Re: PA23-018 – Pilchuck Rentals CUP – Technical Review 1  
Job. No.: 21c-4287

To: Amy Hess  
City of Marysville – Community Development Department  
501 Delta Avenue  
Marysville, WA 98270

### **Technical Review 1**

Drawing:
A1.3
 Job Number:
 21c-4287

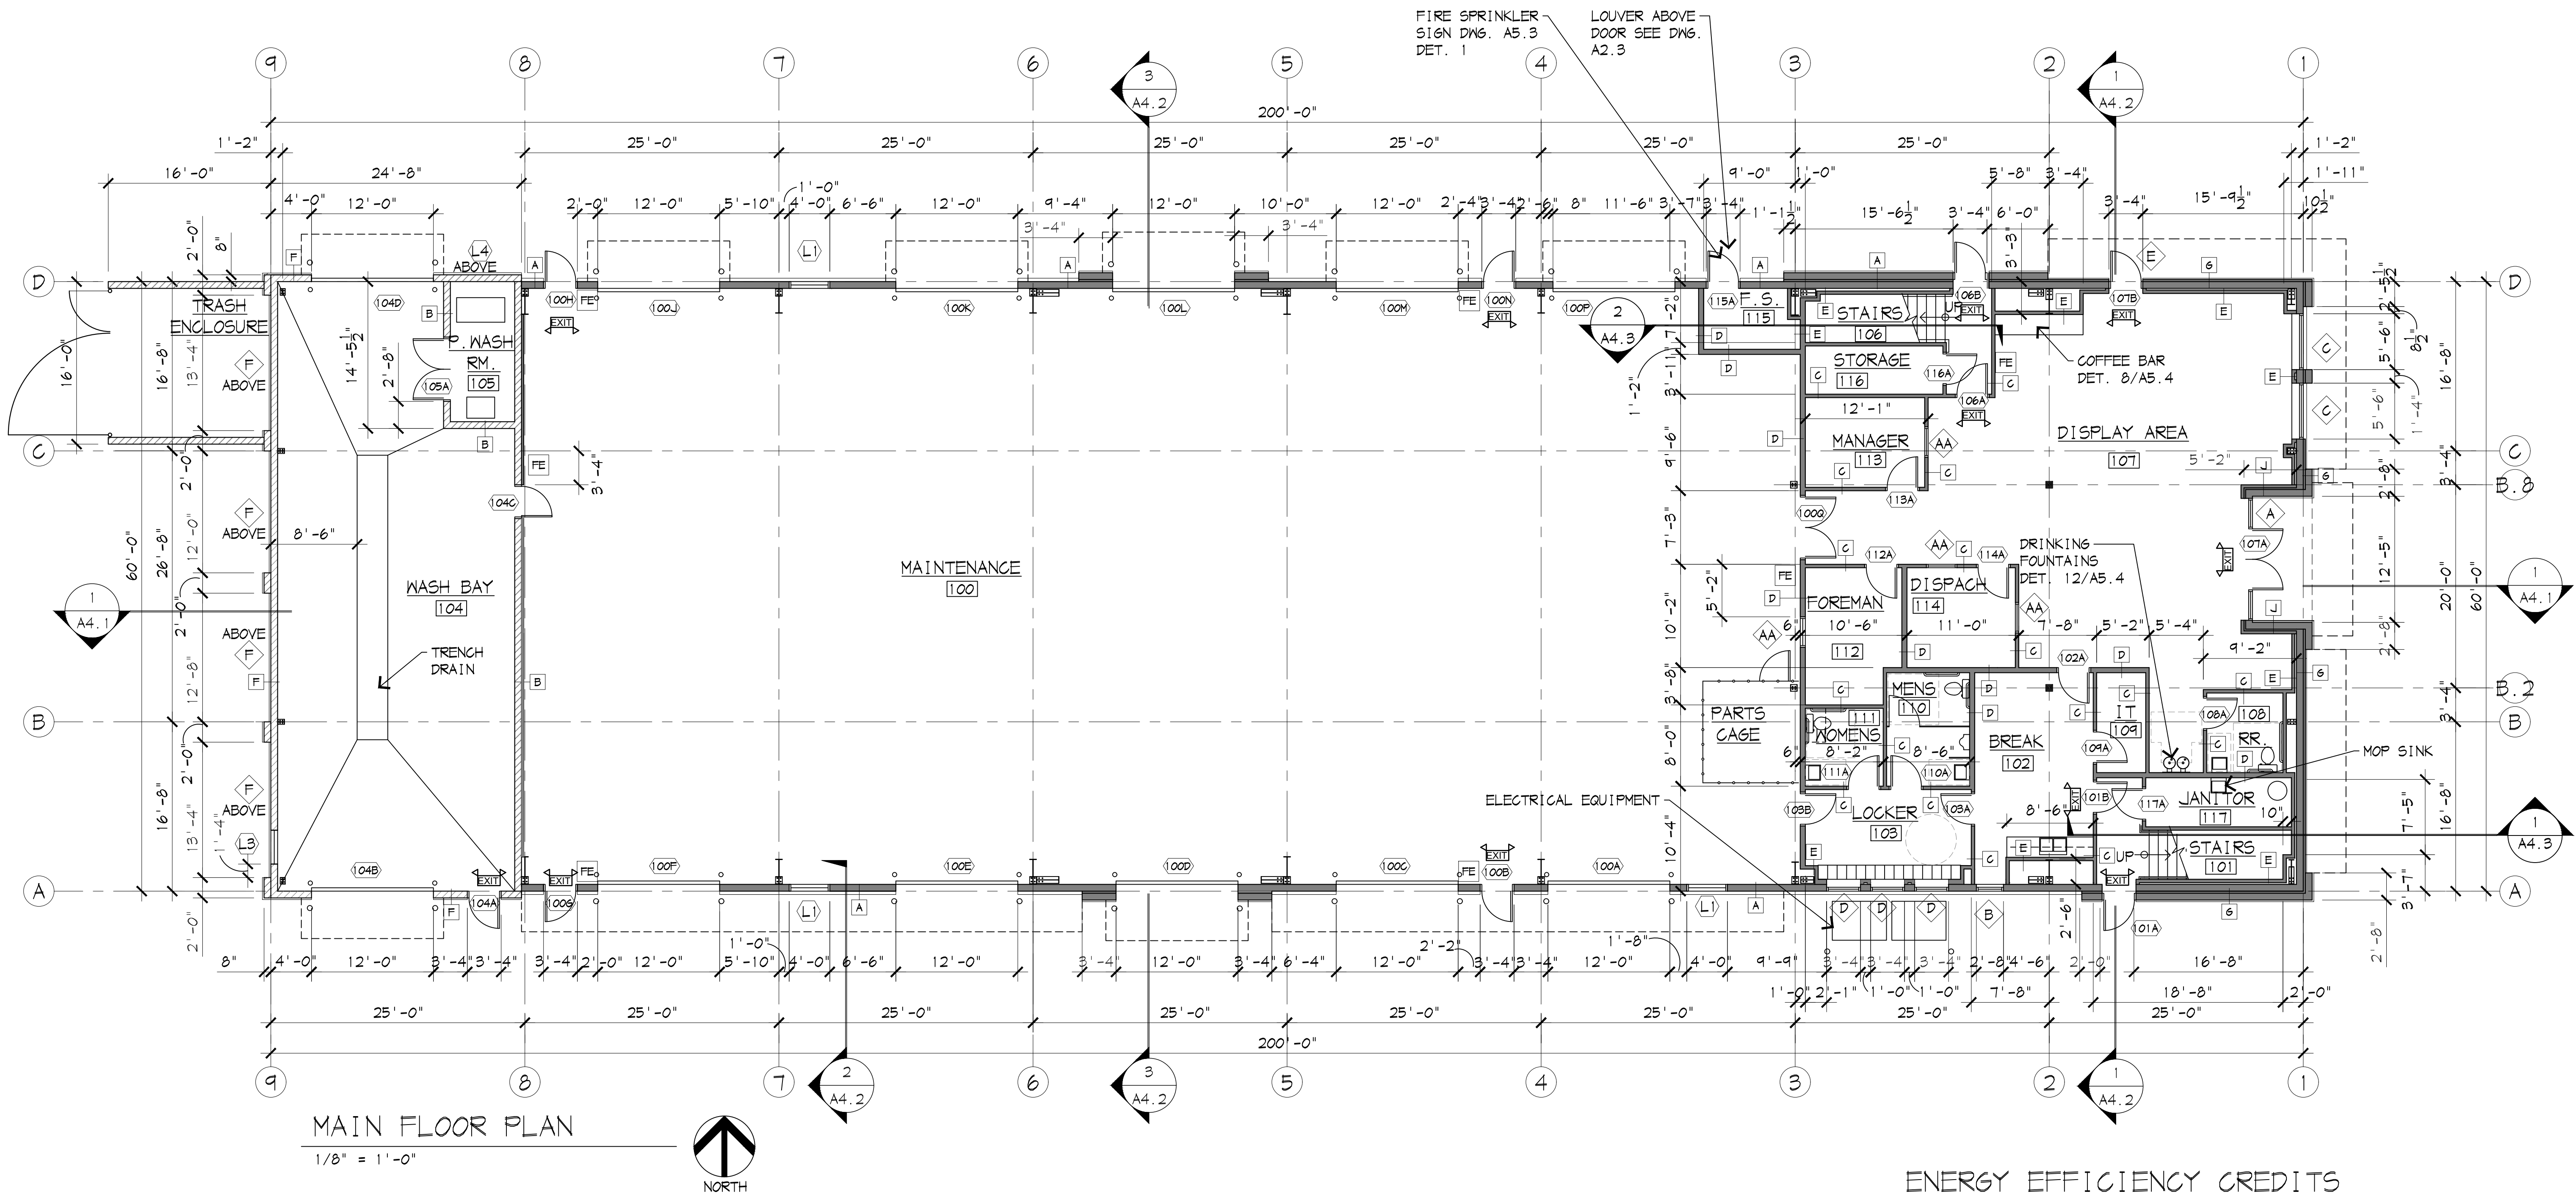
11. Provide a separated sprinkler room with exterior access on the building floor plan.

*A fire sprinkler room with exterior access is provided. Refer to A2.1 for location.*
